**Transport
for NSW**

Mt Owen Continued Operations Project - SSD 5850

Thank you for your correspondence dated 21 January 2015 requesting Transport for NSW (TfNSW) to review and comment on the Environmental Impact Statement for subject proposal.

Figure 2B: Project Layout – Rail Infrastructure Upgrades

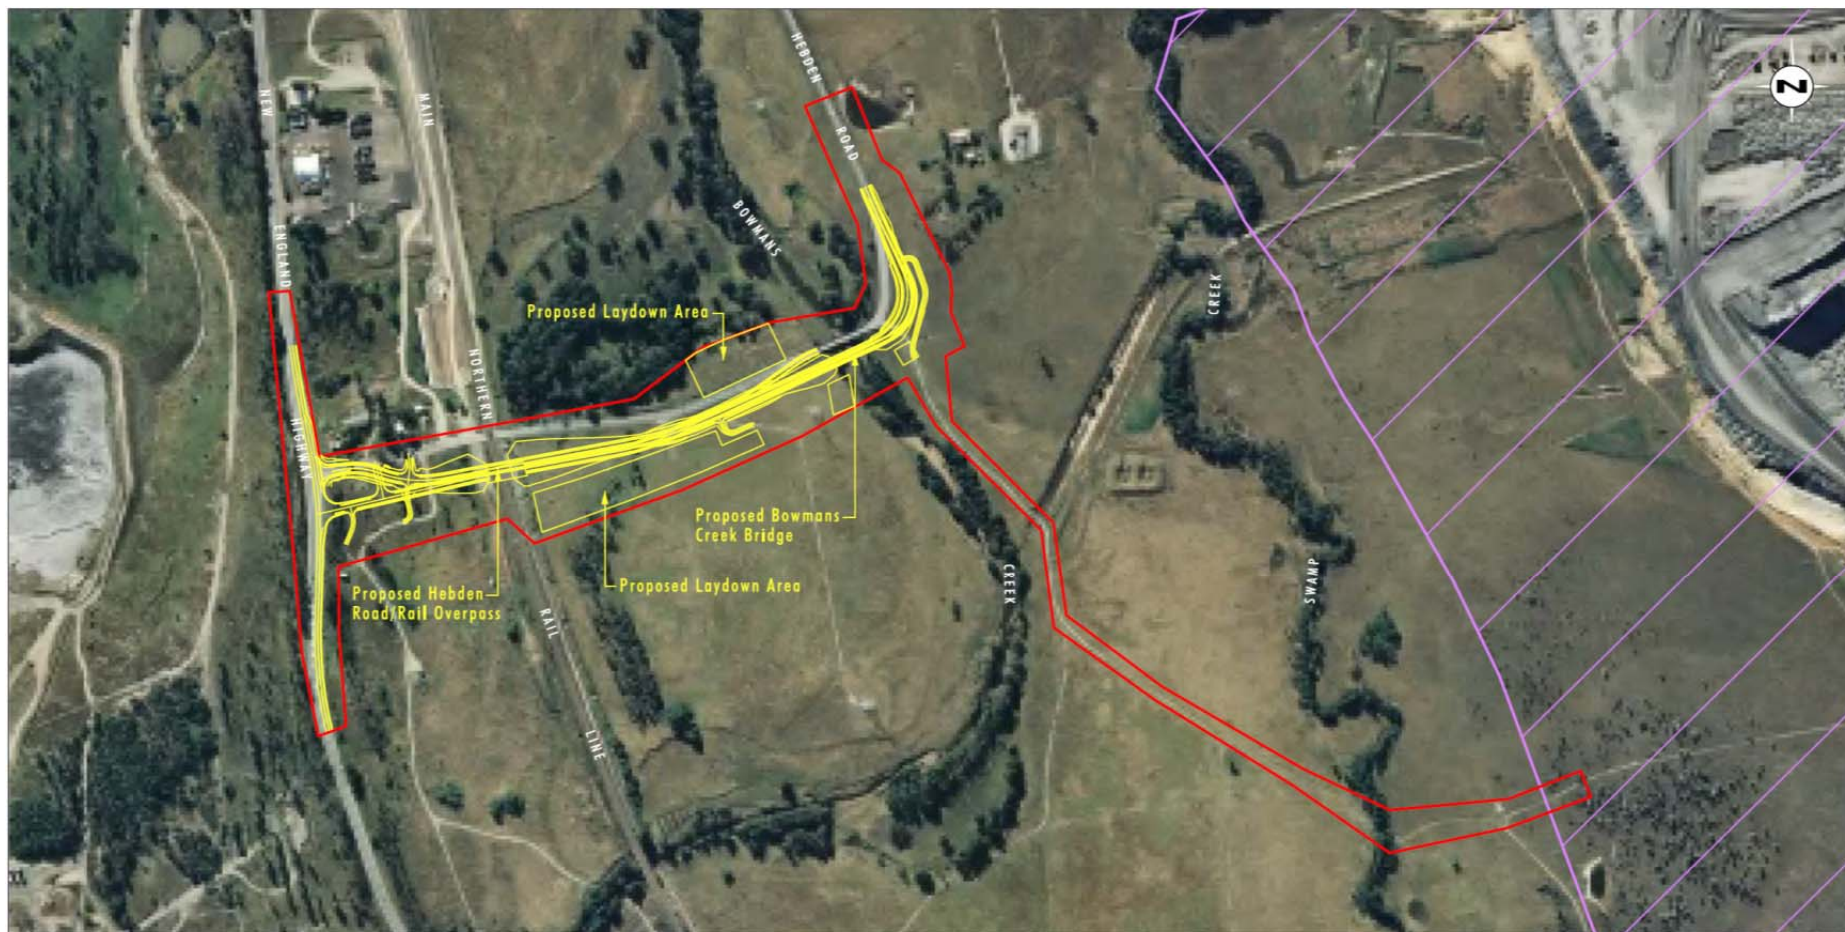
TfNSW has undertaken a review of the documents associated with the proposal and it is advised that the design of the proposed rail infrastructure works and network interface is to be resolved to the satisfaction of Australian Rail Track Corporation's (ARTC).

In addition, the proposed road improvement works on Hebden Road needs to accommodate the swept path of two largest design vehicles travelling in opposing direction. The design and construction of the road works including the preparation of construction traffic management plans should be in accordance with Austroads and Australian Standards and resolved to the satisfaction of Singleton Council and Roads and Maritime Services. The proposed rail overpass over the Main Northern Railway Line will also need to satisfy ARTC's requirements.

The above matters relating to the design of rail infrastructure and road improvement works should be resolved prior to determination and appropriate conditions included in the consent to the satisfaction of ARTC, Singleton Council and Roads and Maritime Services.
